NORFOLK VANGUARD OFFSHORE WIND FARM

CAWSTON PARISH COUNCIL SUBMISSION FOR DEADLINE 5

CABLE ROUTE NORTH OF CAWSTON VILLAGE

Title: Land Plans
Sheet 19

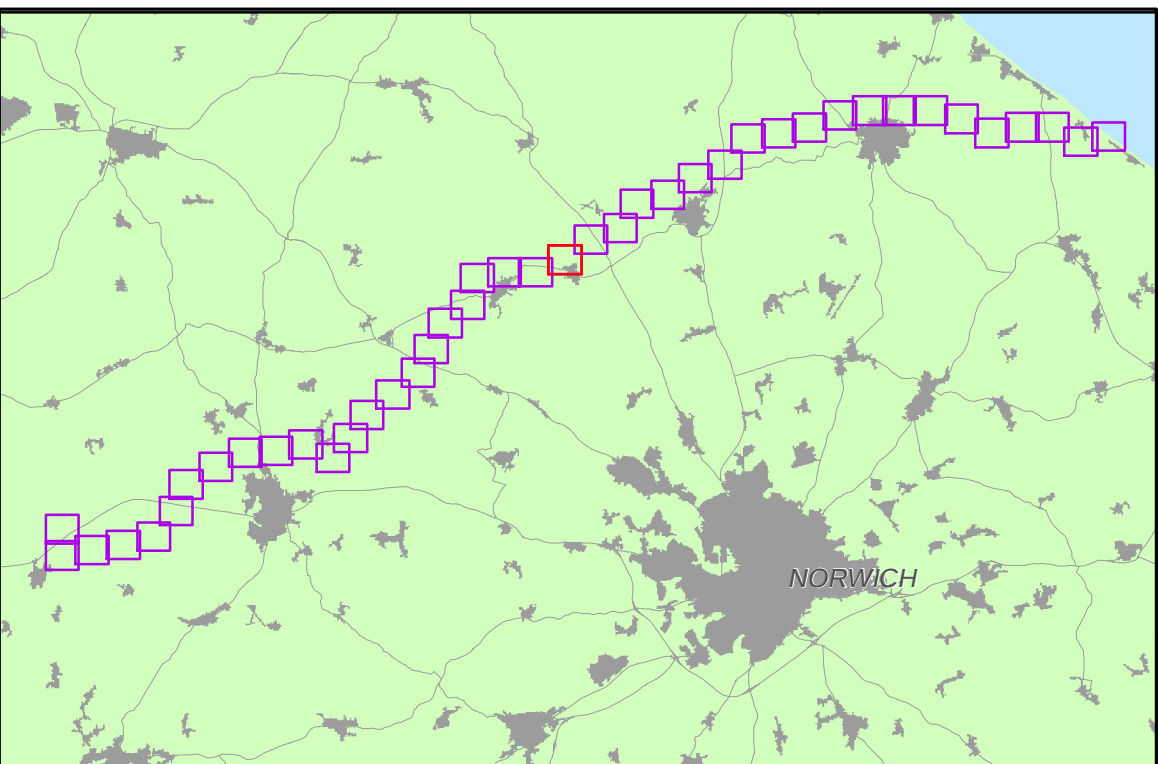
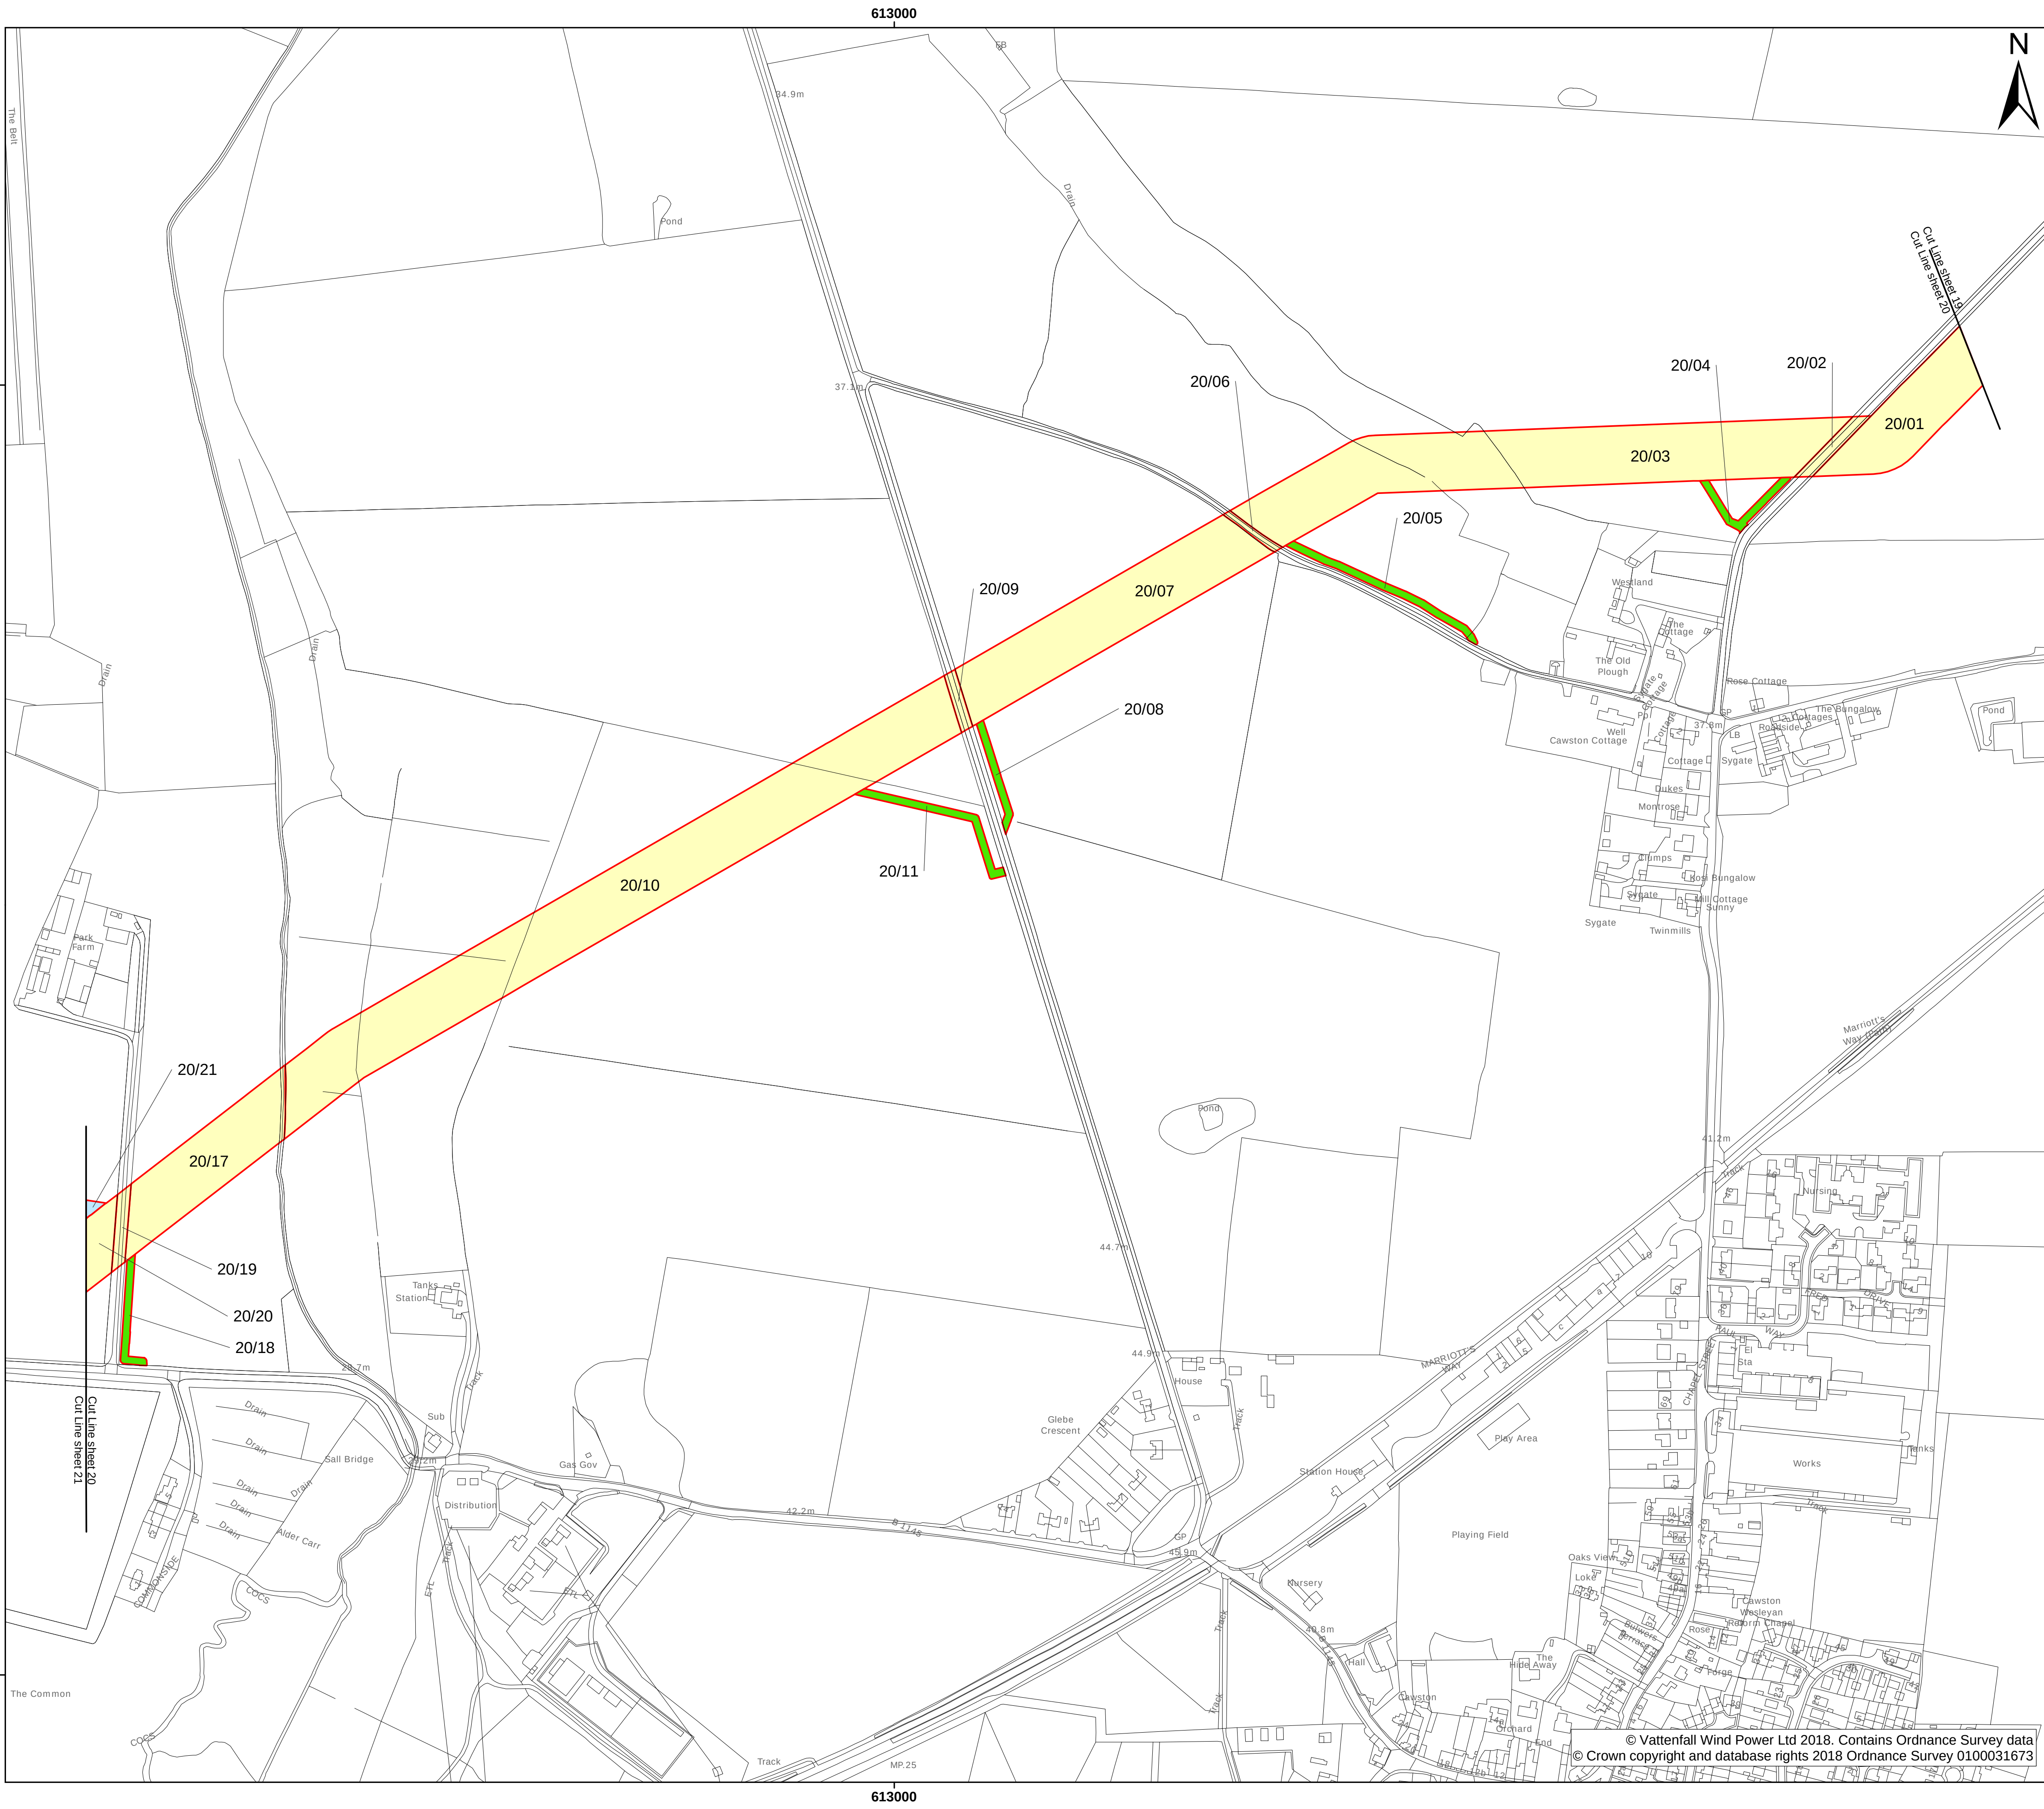
Cawston Parish Council is concerned about the proximity of the Norfolk Vanguard Cable Route to residential properties in the hamlet of Sygate to the north of Cawston village.

The proposed cable route crosses the lane linking Cawston and Oulton around 30 metres from the boundary of "Westland" and approximately 70 metres from the house. A slight realignment of the cable route and its crossing of the lane could put the route and its associated environmental impact at a distance of more than 200 metres from Westland and a similar distance from Beerhouse Farm. The cable route near Beerhouse Cottages and Sovereign Cottages could be similarly realigned to reduce its impact on those properties.

Cawston Parish Council requests that the cable route in this section is realigned to mitigate its impact on the amenity of residents. It seems that when the cable route was designed for this area the impact on residential properties nearby was not given a high enough priority.
